MECKLENBURG COUNTY  
Park and Recreation Department

MEMORANDUM

**RE:** Rezoning Petition #2024-006  
PID# 13314101

SHEET NUMBER  
**RZ-1**

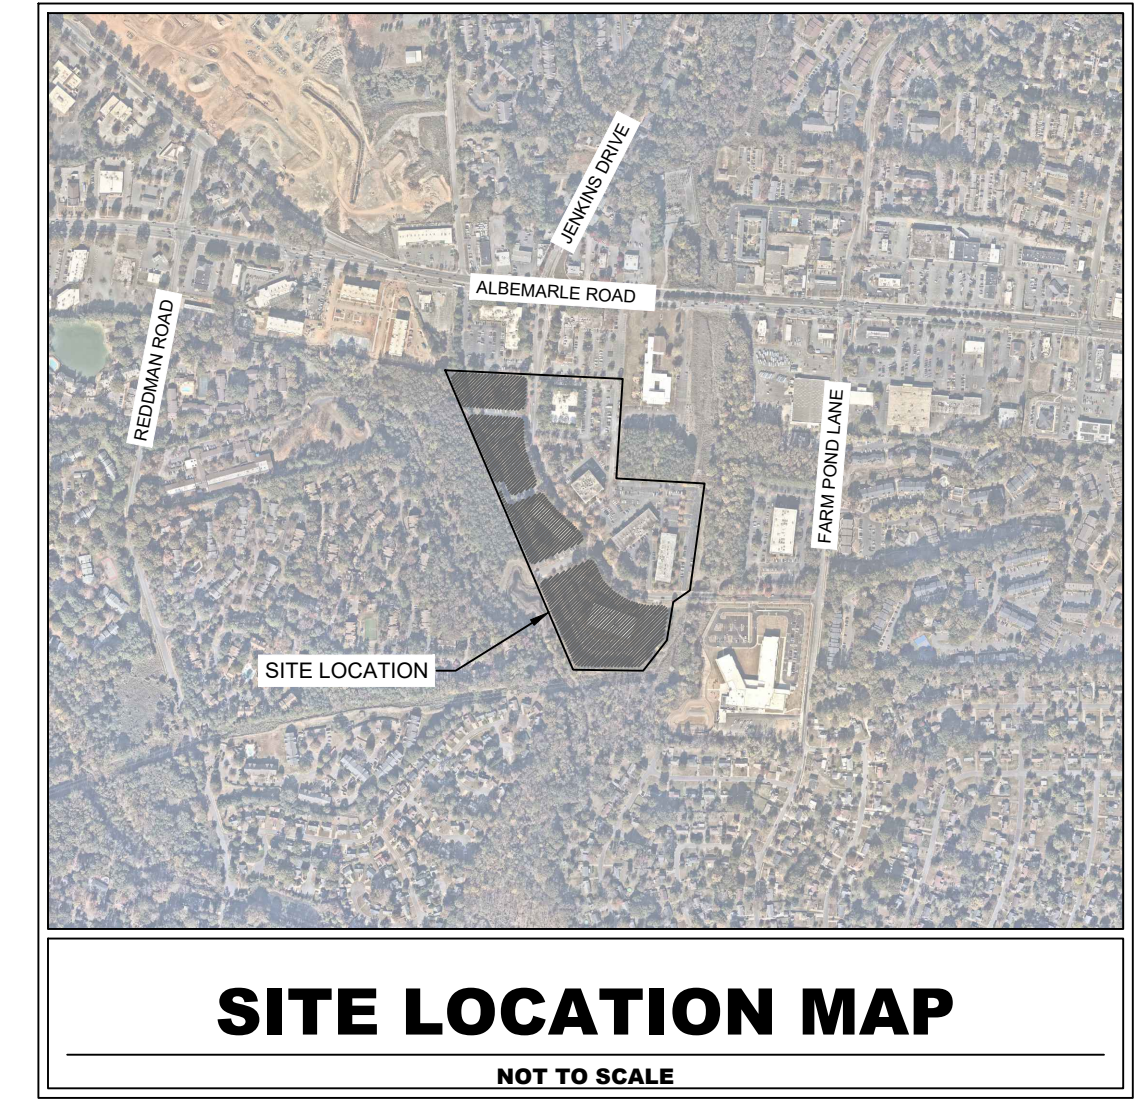
Please provide pedestrian and bicycle accommodations along the frontage of Executive Center Drive to connect to the funded Campbell Creek Greenway Trail project.

The rezoning acreage appears to have reduced from 25.7 acres to 13.6 acres since the first submittal. If the acreage was reduced, MCPR rescinds the request for a minimum of 1.25 acres to be dedicated and conveyed to Mecklenburg County for a future neighborhood park. However, MCPR would be interested in working with the petitioner on a local park site within the development if interested.
